AQUIND INTERCONNECTOR

Applicant's Response to Deadline 4
Submissions

Including Winchester City Council comments at
Deadline 6 (25 January 2021)

Document Ref: 7.9.23

Aquid Countryside Option

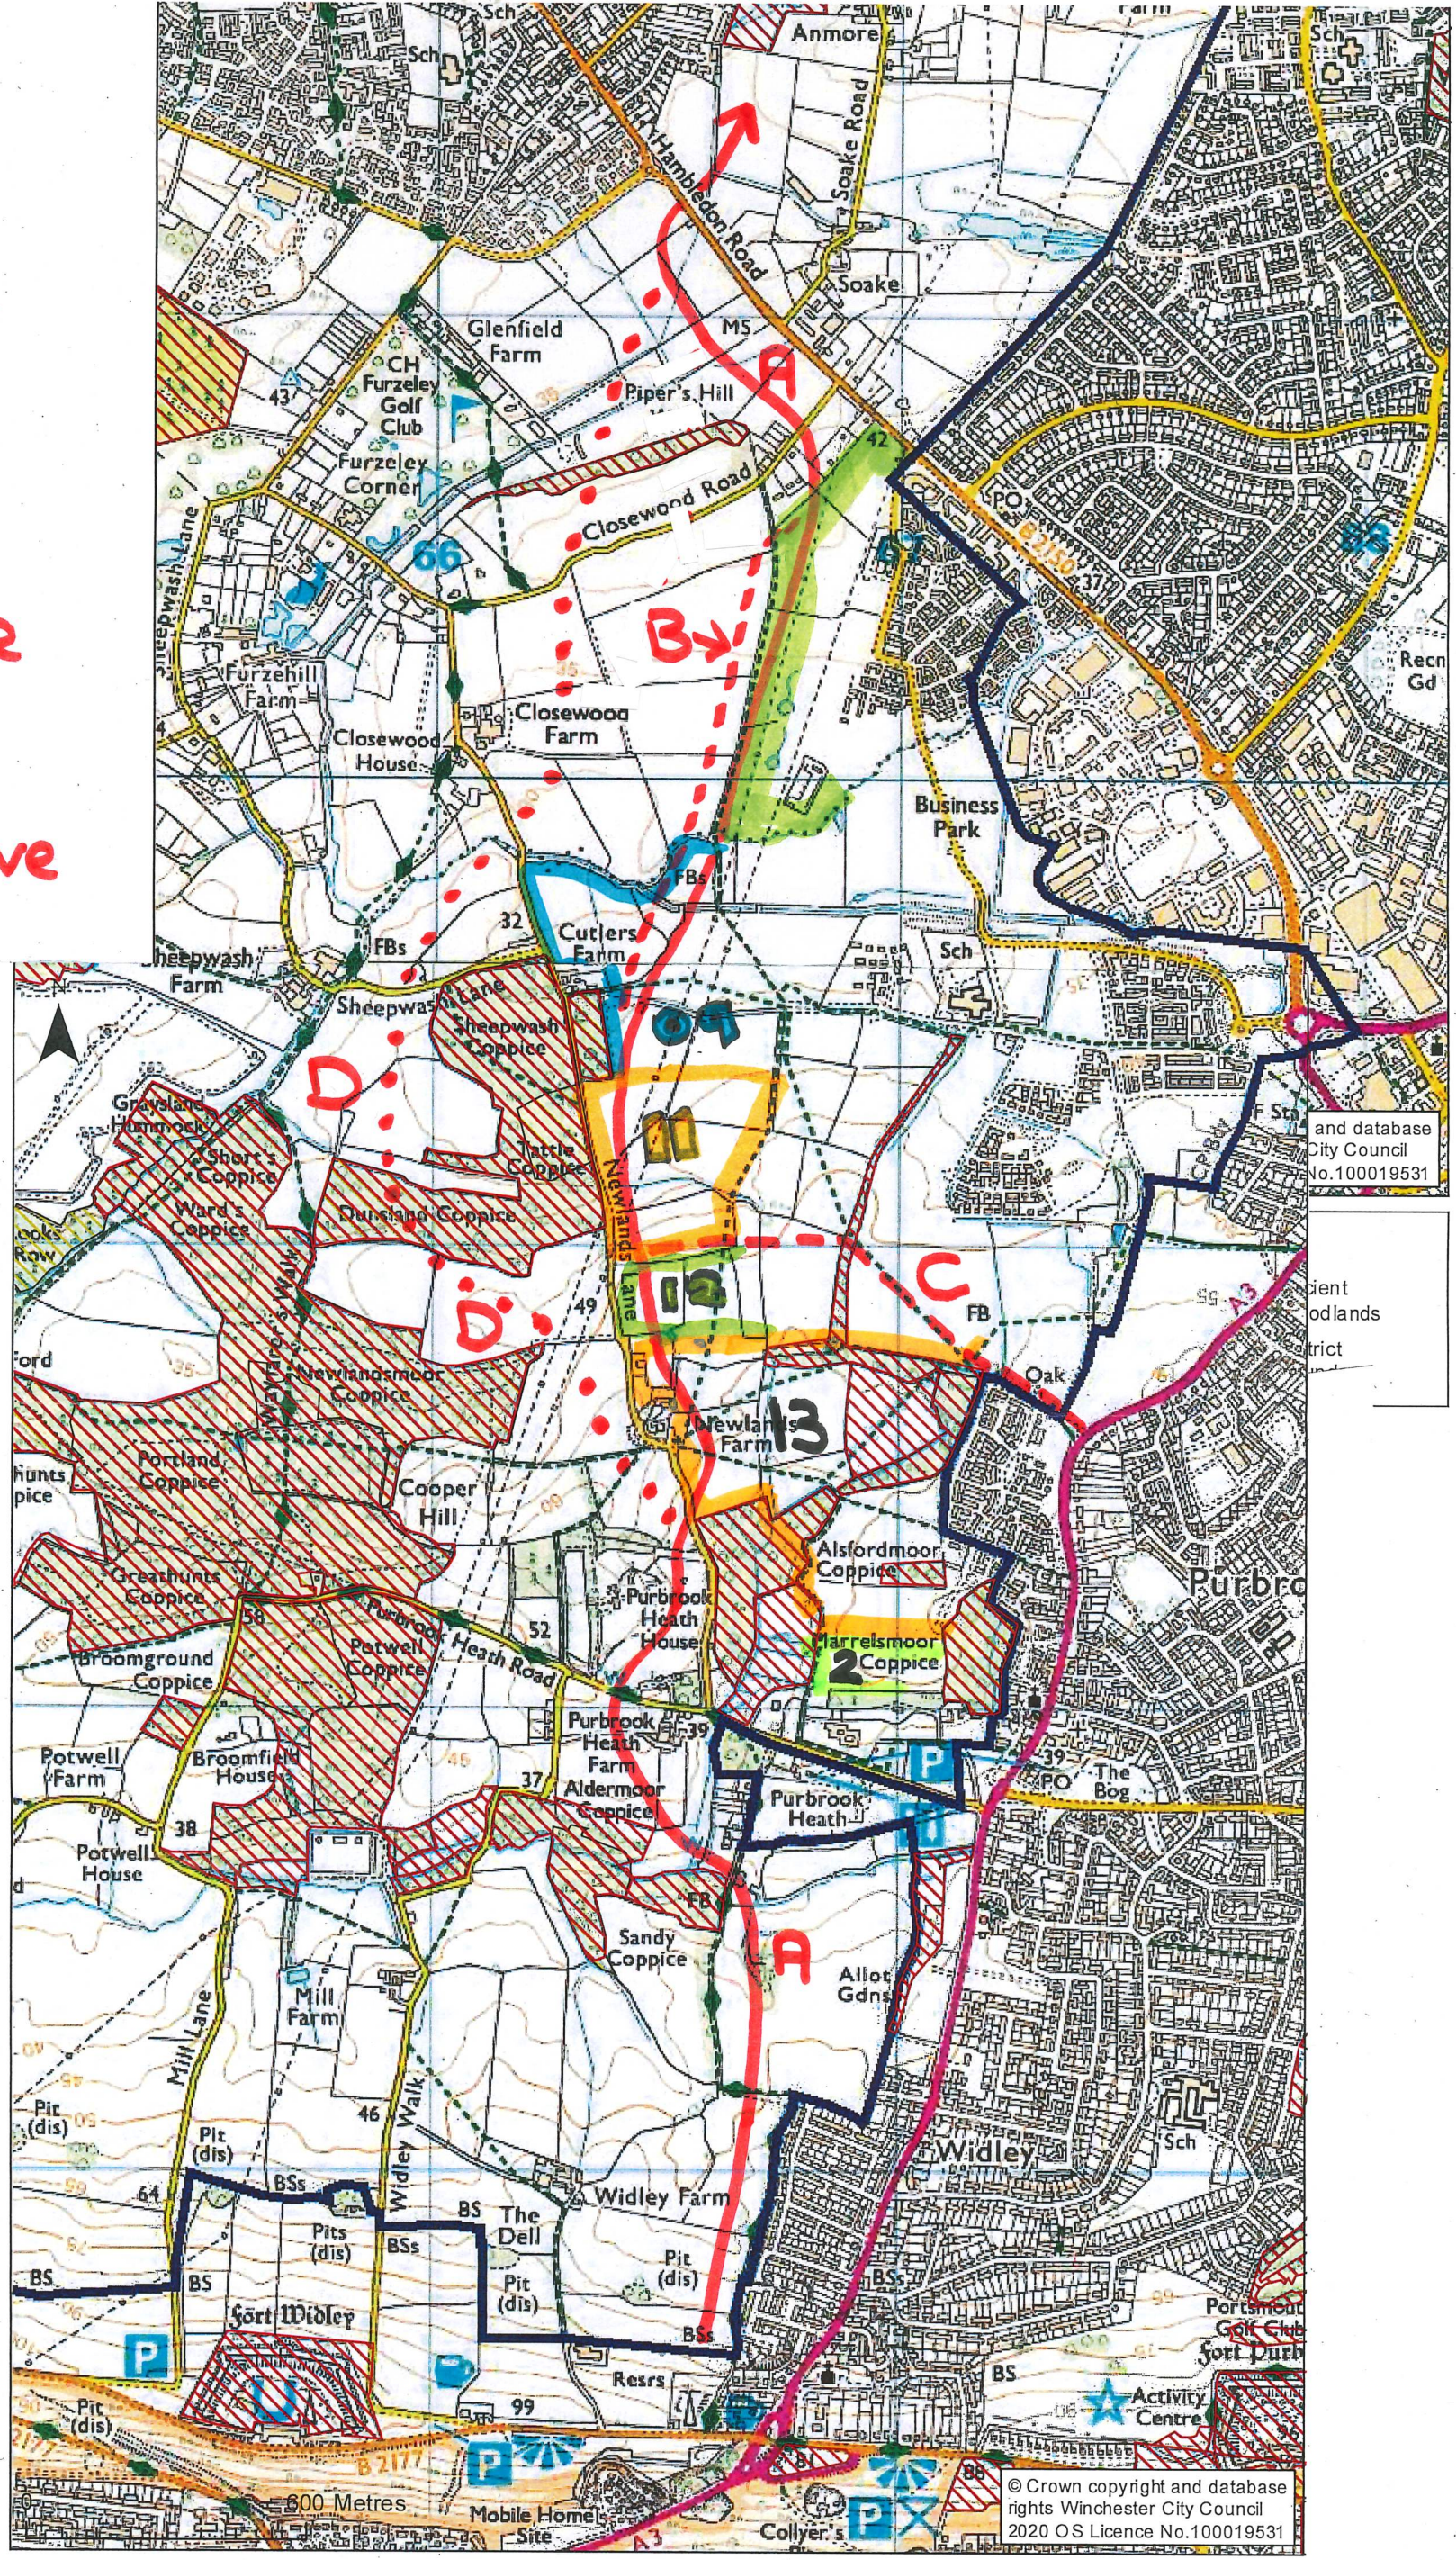
<p>WCC does not prejudge that a countryside route would be acceptable, however, the Council questions if the countryside route featured in the Applicant's site assessment decision making process.</p> <p>In addition, the Council continue to raise concerns regarding the discounting of the 'Countryside Route'. Including the Applicant's view that seeking to route the cable circuits along the Countryside Route risks sterilisation of land and would have presented a potentially significant consenting risk.</p>	<p>A cross-country option was considered in 2017 and 2018, including following the receipt of feedback from local authorities to further look into non-highway options.</p> <p>A route through the fields, adjacent to the A3 to the west, has been fully considered by the Applicant in a proportionate manner. A review of environmental designations and constraints showed areas of Priority Habitat, Sites of Importance for Nature Conservation (SINCs) and Ancient and Replanted Woodland. As well as environmental constraints, other important factors such as private land, compulsory acquisition requirements, and potential for future development (including strategic housing allocations) were taken into account. The Applicant's reasoned conclusion was that a route across the countryside in this location was not preferable as an alternative to the route selected and should not be pursued.</p> <p>The Applicant identified land sterilisation (putting restrictions on a plot or portion of land to prohibit all/some building/improvements) as a constraint West of Waterloooville as installing underground cables and joint bays would require the exclusion of development (including landscaping) above the cable route and for an area of typically 11m in width for potentially up to 5km to allow future access, where necessary. The land above the cable route would need to be kept clear from development and any significant vegetation. This would apply to the permanent easement of the cable route. This would therefore significantly constrain any proposed development in proximity to the cables.</p>	<p>Please identify the specific sections within chapter 2 of the ES where this consideration in 2017 &2018 is referred to. Please confirm that any consideration did review this specific cross country route from Portsdown Hill up to the Hambledon Road and that this was not a reference to other routes from other landfall points under consideration at the time.</p> <p>To date, despite all the responses from the applicant the timeline of actions does not support their version of events.</p> <p>The issues over sterilisation have been responded to in the past.</p>

Para No.	Summary of Deadline 4 Submission	Applicant's Response at Deadline 6	
	<p>The chronological optioneering process as set out in Chapter 2 of the ES does not support the 2018 date put forward by the applicant. Nor is there any indication that the Countryside Route featured in any meaningful way in the decision making process that the applicant followed.</p> <p>The Council cannot find any reference to the countryside option in the optioneering section.</p> <p>The connection point to the grid was offered to the applicant by NGET in February 2016. (2.4.4.3).</p> <p>At that time the landfall had not decided.</p> <p>The number of potential landfall points was gradually reduced from an original figure of 29 (April 2015)</p> <p>During the Onshore Routes Desktop Study Q2 2016 (2.4.6), the UK Cable Route Desk Top Study February 2017 (2.4.11) and the UK Terrestrial Routes & Landfall Workshop June 2017 (2.4.14.1) there is no indication that the countryside route was considered at all. "Section 2.4.14.8 says Eastney and Route 3D where selected.</p> <p>It would therefore appear that before 2018 the road option (3D) had chosen...</p>	<p>A section is included within ES Chapter 2 (Consideration of Alternatives) to illustrate that HBC and WCC's suggestion had been considered, stating that it was considered that the impact associated with the countryside route outweighs temporary short-term impact on traffic, and the countryside route options suggested by WCC and HBC <u>were not</u> considered to be <u>reasonable alternatives</u> to the highway route proposed during the statutory consultation and thus not taken forward.</p> <p>The overall philosophy applied to the consideration of the reasonable alternatives, or the options, for the Proposed Development by the Applicant is explained at paragraph 2.3 of Chapter 2 of the ES. This explains that a process of staged filtering was applied, increasing knowledge of the individual options, so as to proportionately consider them from a technical, cost and environmental perspective. A proportionate multidisciplinary approach was taken to the assessment of the reasonable alternatives, taking into account considerations relevant to and specialist input from experts in the fields of electrical engineering, cable engineering, the environment, planning and civil engineering in respect of both the onshore and marine environments.</p> <p>So as to provide as clear an explanation as is possible, the applicant submitted a supplementary chapter to provide further context behind the iterative process, and how relevant elements were considered. There is inevitably some cross over between the relevant considerations in relation to the individual aspects.</p> <p>Further information in relation to the consideration of the countryside route is provided in response to question 9.2, and further information in relation to the scope and nature of various studies undertaken, in chronological order, is provided in the response to question 9.3, in the Applicant's Transcript of Oral Submissions for Compulsory Acquisition Hearing 1 (REP5-034).</p>
